### **EPA Submission on Planning Advice Request**

Thank you for the request for advice from the Department of Planning, Industry and Environment (Planning) in which you requested a review by the NSW Environment Protection Authority (EPA) of the Applicants Second Revised Response to Submissions for the proposed Ingleburn Resource Recovery Facility (SSD-8593)(Proposal) at Bulk Recovery Solutions Pty Ltd (BRS), 16 Kerr Road, Ingleburn.

## NSW Environment Protection Authority (EPA) Submission on the Second Revised Response to Submissions for proposed expansion of an existing resource recovery facility (Application SSD-8593) at 16 Kerr Road, Ingleburn

Public Authority Consultation (PAE- 10941429)  
11 December 2020

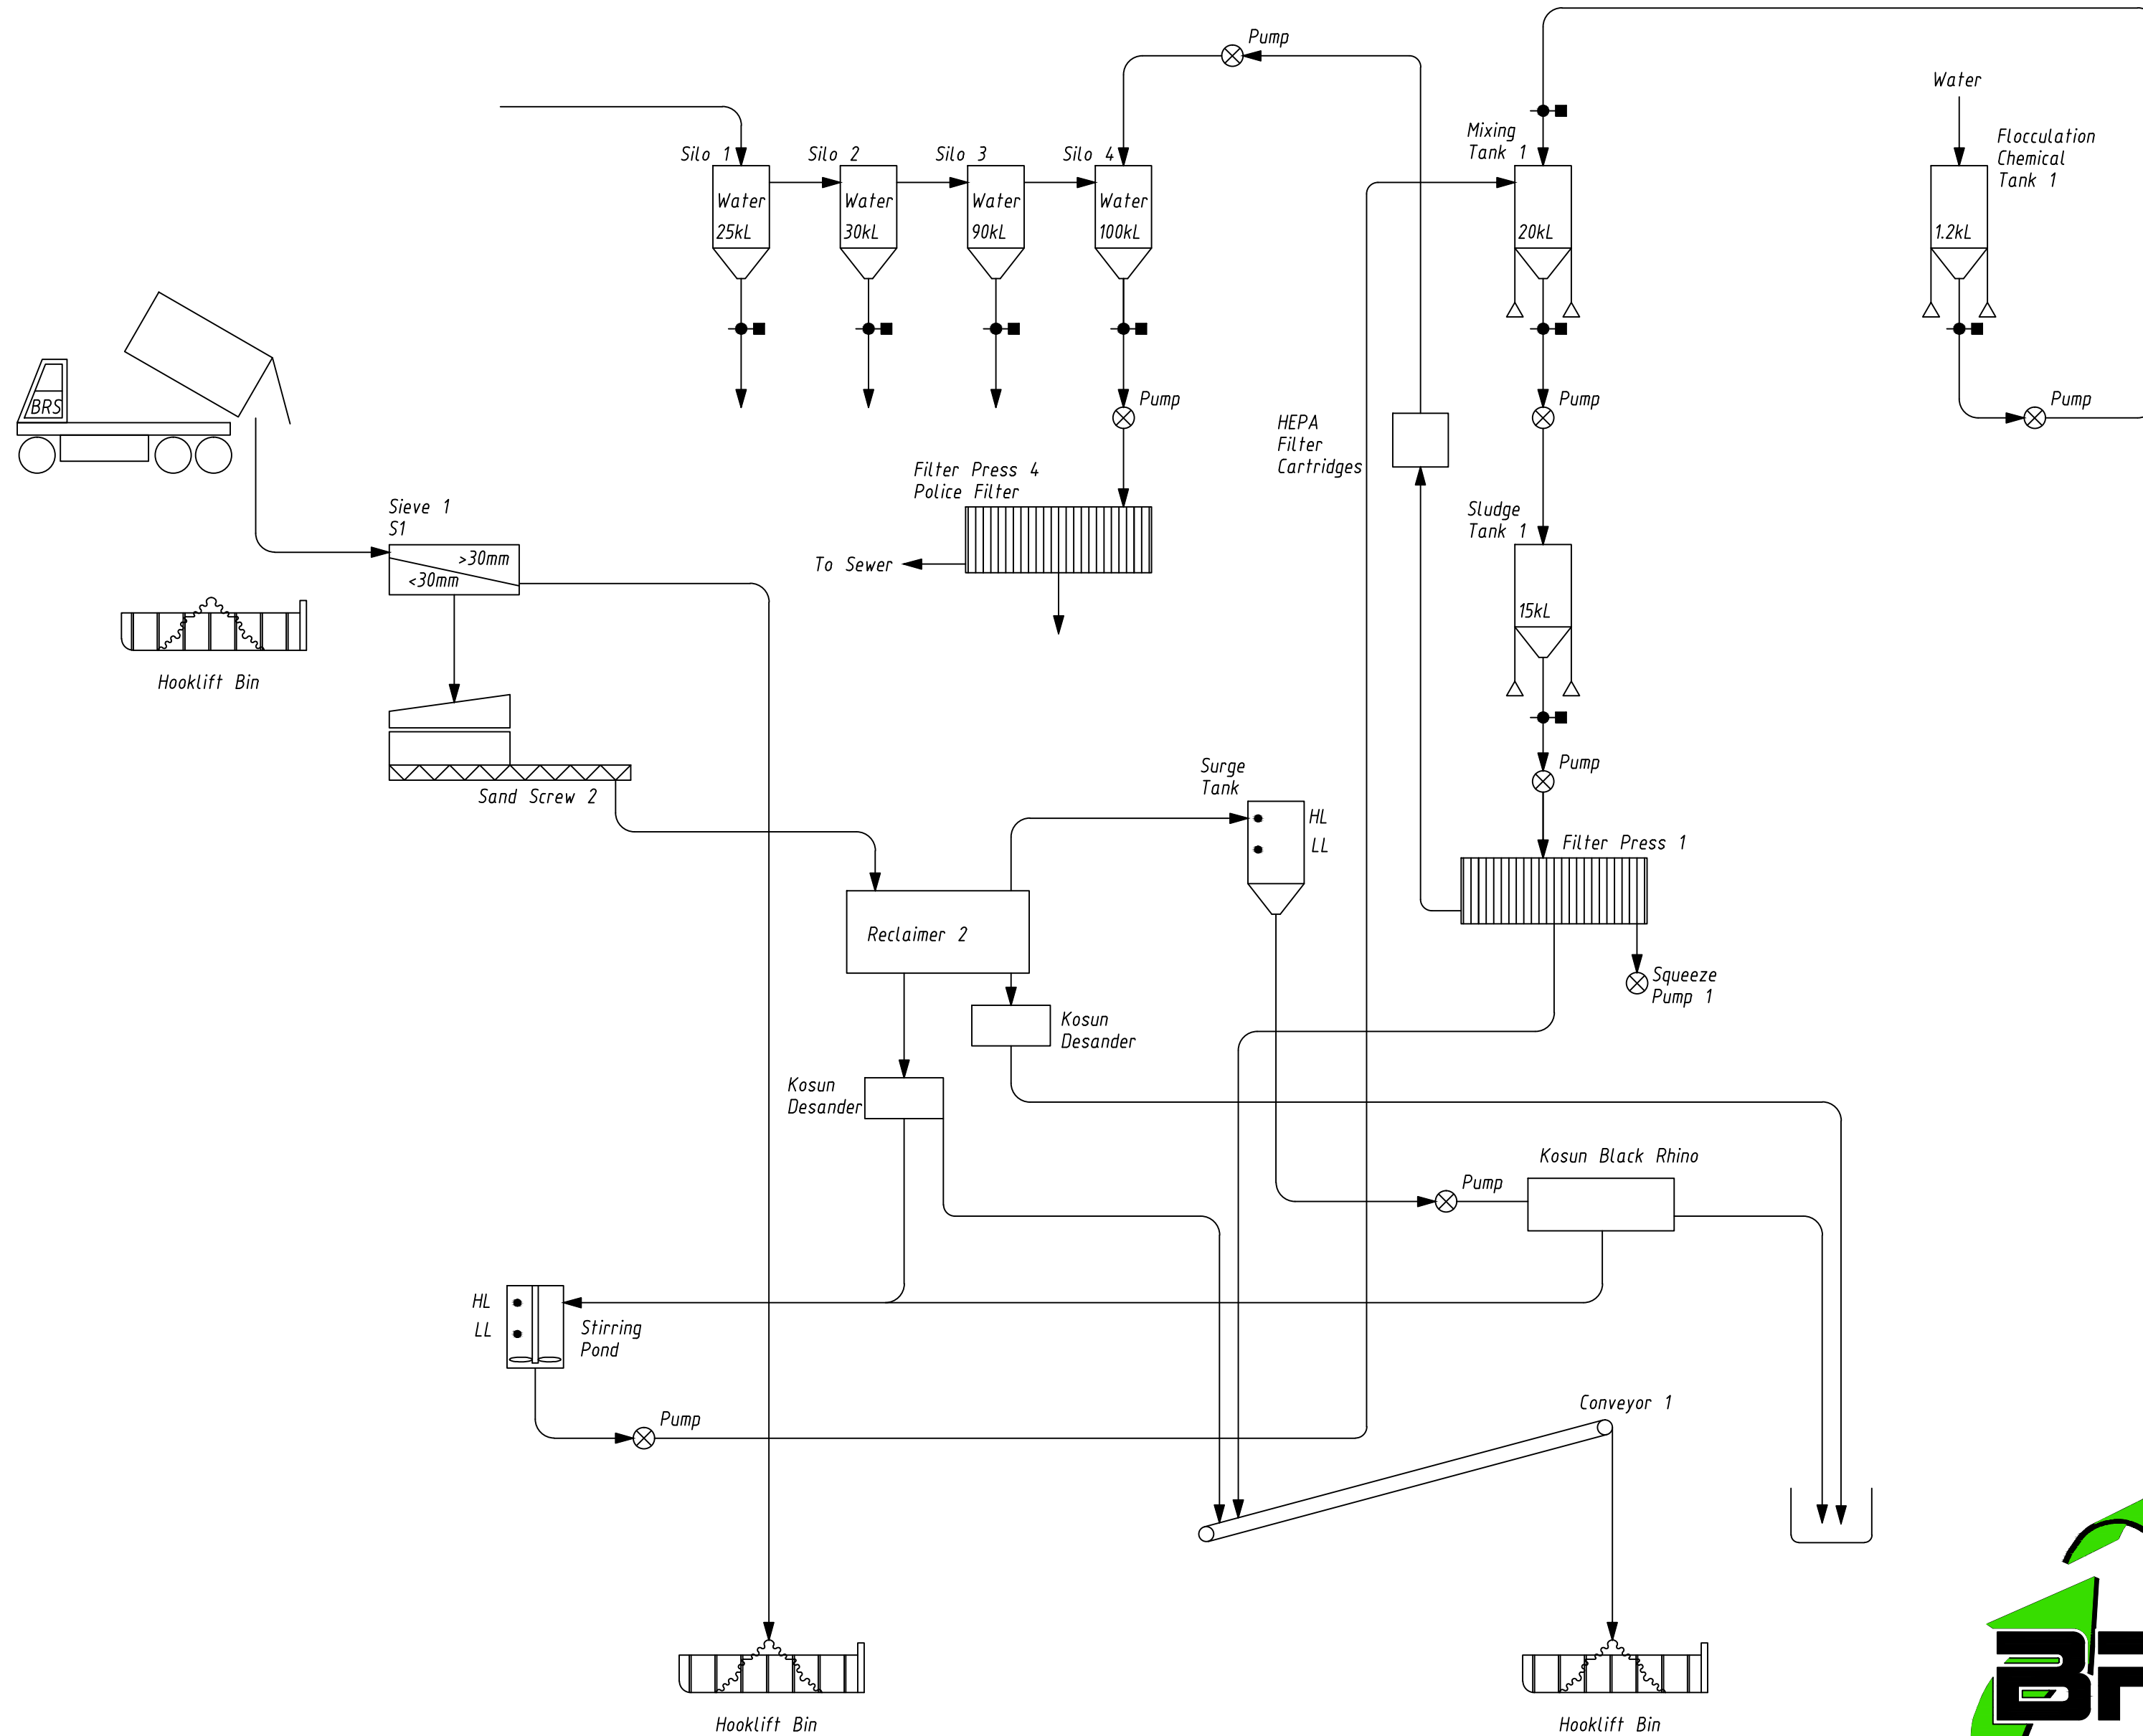
The EPA notes the method proposed to treat Asbestos Containing Liquid (ACL) has been revised in the RRRtS. Sufficient detail has not been provided about this waste and how it will be treated managed on site prior to removal.

The new method proposes to add a combination of cement, lime, fly ash, perlite, or vermiculite to the liquid waste slurry via an auger feeder to immobilise the liquid content contained within the soil or sludge. The waste would then be cured and tested against the EPA's waste classification guidelines.

Under the proposed methodology, vehicles would be washed down inside the asbestos treatment room before leaving the site via an external wheel wash. Asbestos transferred from vehicles to the wheel wash is a relevant asbestos transport pathway that may result in asbestos contaminated water being discharged to sewer.

The proposal should demonstrate the implementation of best practice controls and mitigation measures through all stages of receipt and handling and clarify how potential asbestos contamination in wheel wash waters will be managed.

- i. engage a suitably qualified expert to review all proposed asbestos control measures and the processes that will be implemented to maintain these.
- ii. consider the potential for asbestos to impact wheel wash waters, and develop and propose appropriate management measures, consistent with best practice.
